Project No. 21071

Re: SUB23-004 - Request for Information One – Design Built Homes two lot short subdivision.4719 86th Avenue SE, Mercer Island WA 98040, Parcel number: 7598100420

This letter is provided as response to comments dated September 13, 2023. Each item has been carefully reviewed and considered and the following is a summary of how each item was addressed.

DRAWING: C2
SHEET: 2 OF 4

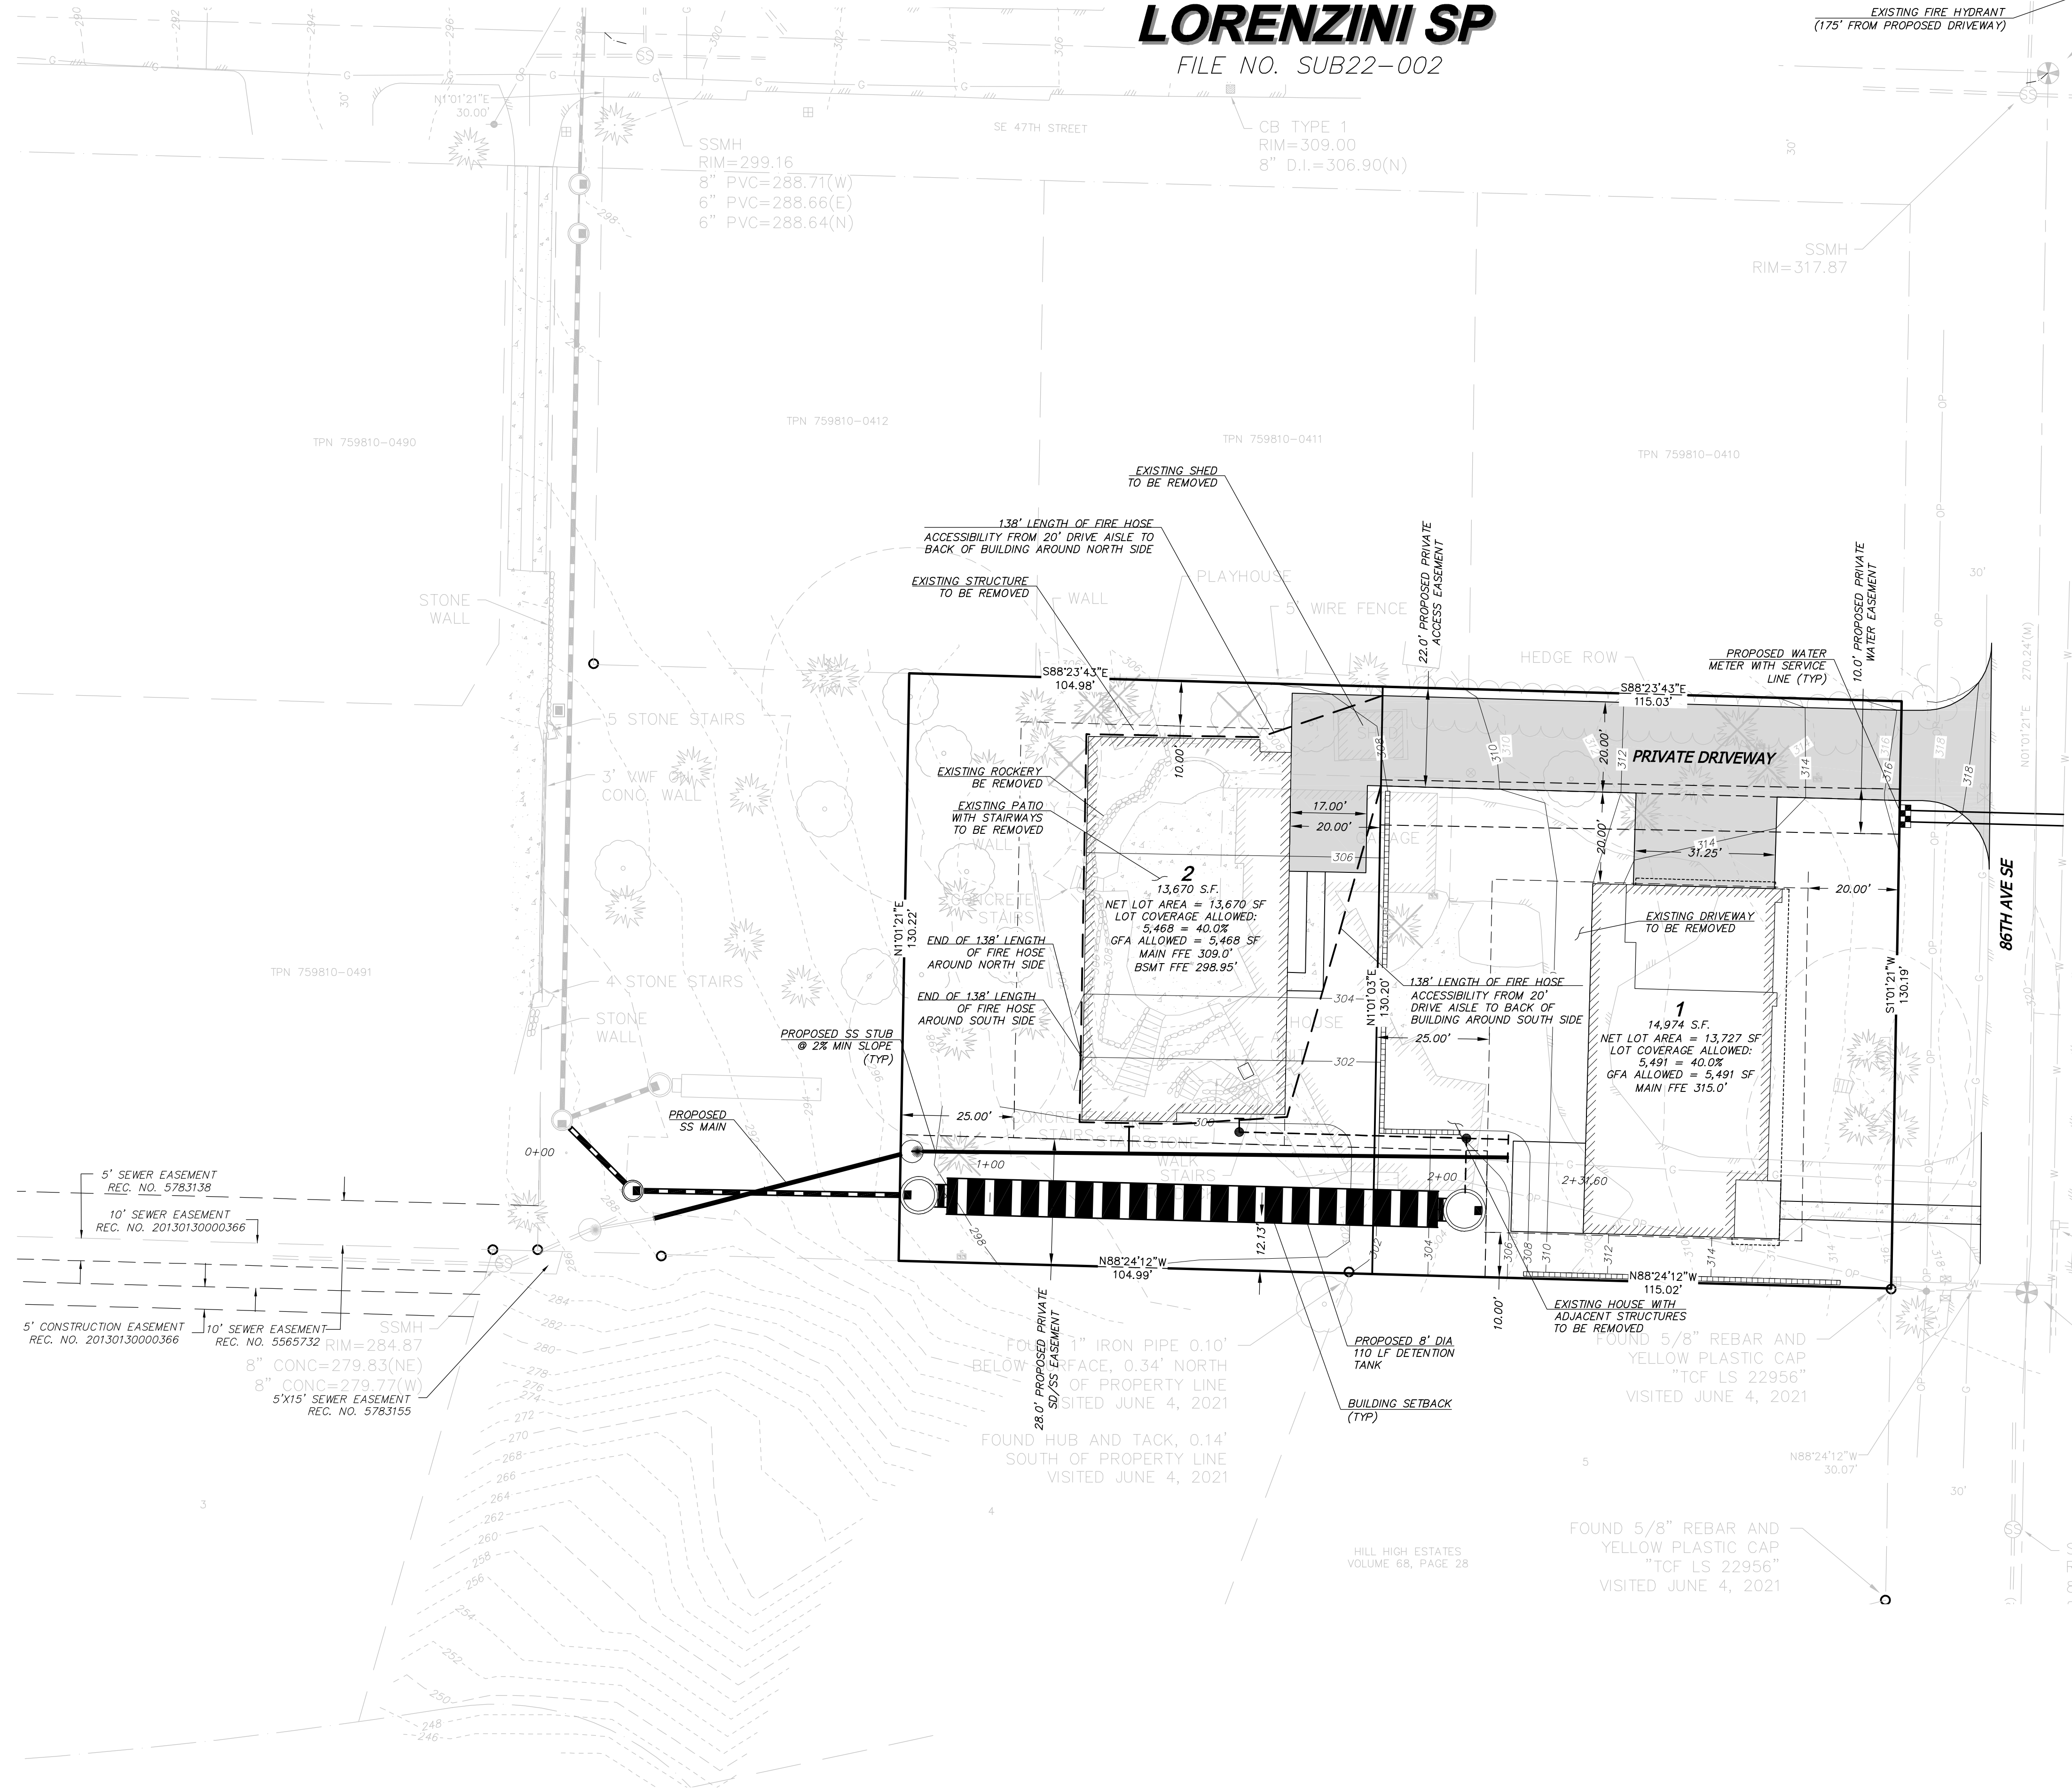
1. This short plat application involves work on and the creation of easements on an adjacent lot parcel number 759810-0421 which is not a part of this short application. please remove the proposed easements and proposed improvements from this short plat application.

Proposed easements have been removed from the Short Plat Application. The structures that the Short Plat utilities are tying into are now built and shown as existing.

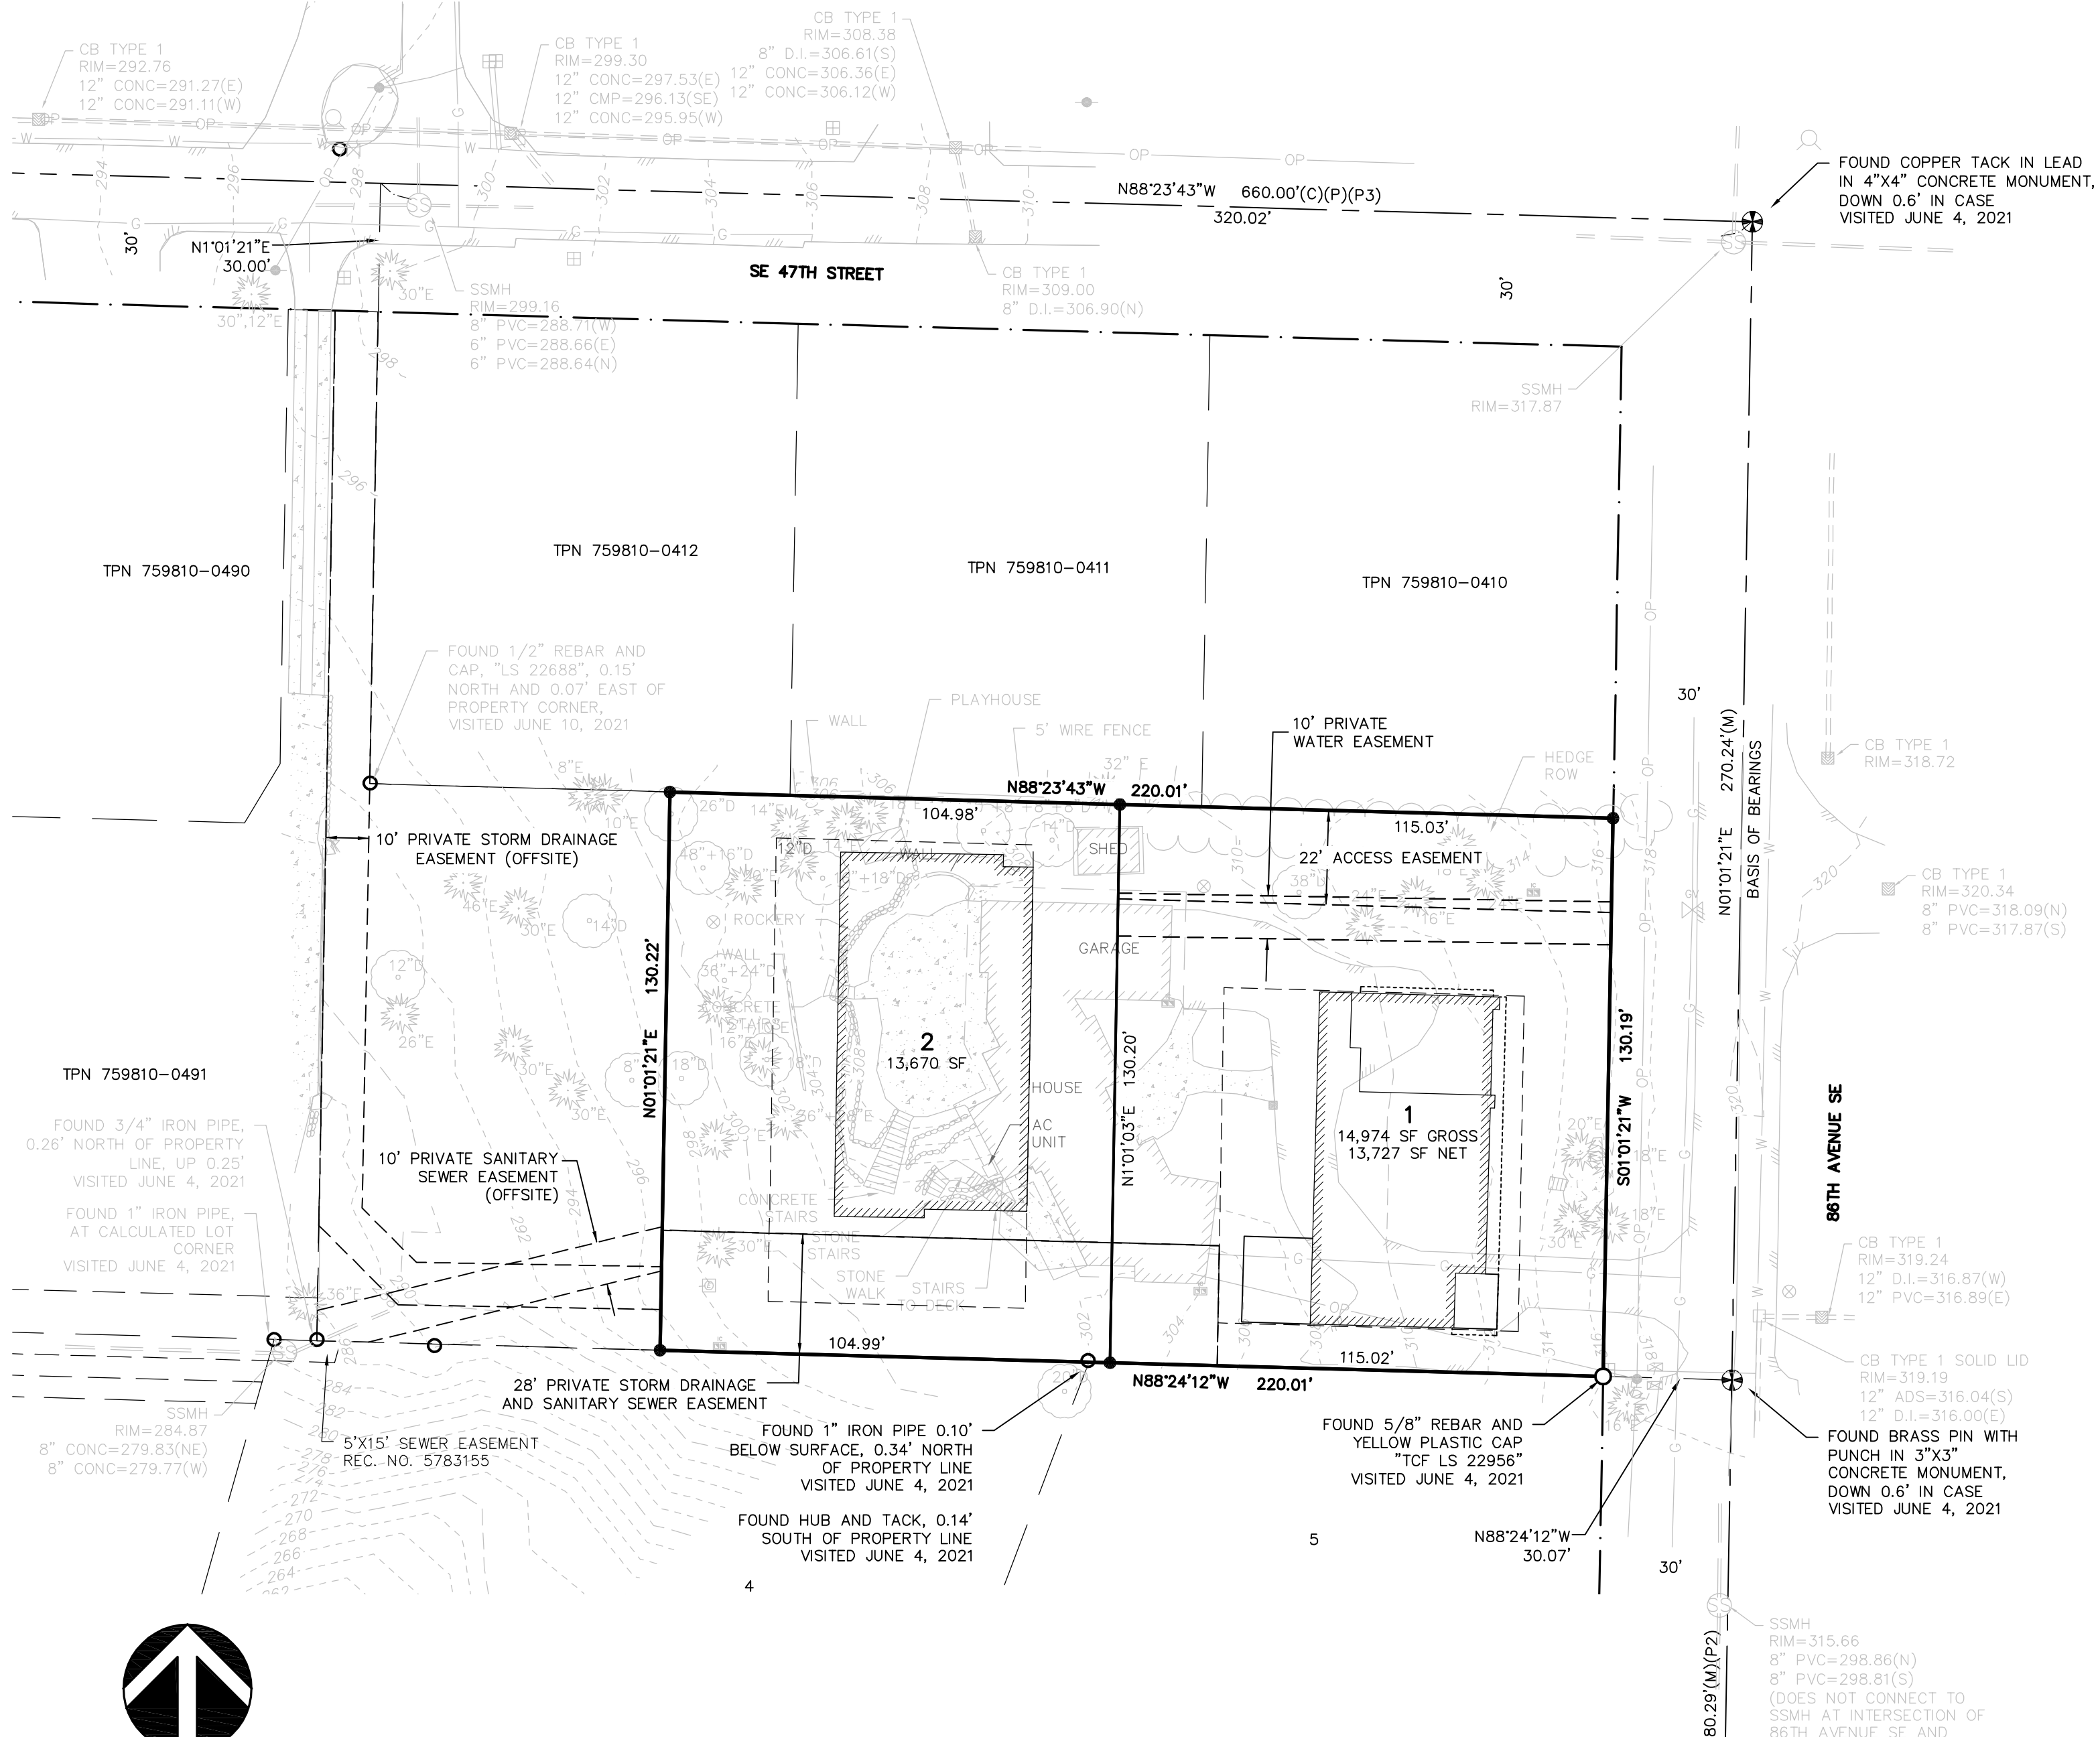
9. Plat Map Note- Please include this note on your plat map.

%All building permits are subject to meeting current fire code requirements at the time of a complete submittal, including fire apparatus access as outlined in adopted code sections of the International Fire Code Appendix D. Fire plan reviews will be conducted at time of building

permit submittal and may require additional fire protection systems and/or additional fire prevention measures for building approval.+

Note has been added to the Plat Map.
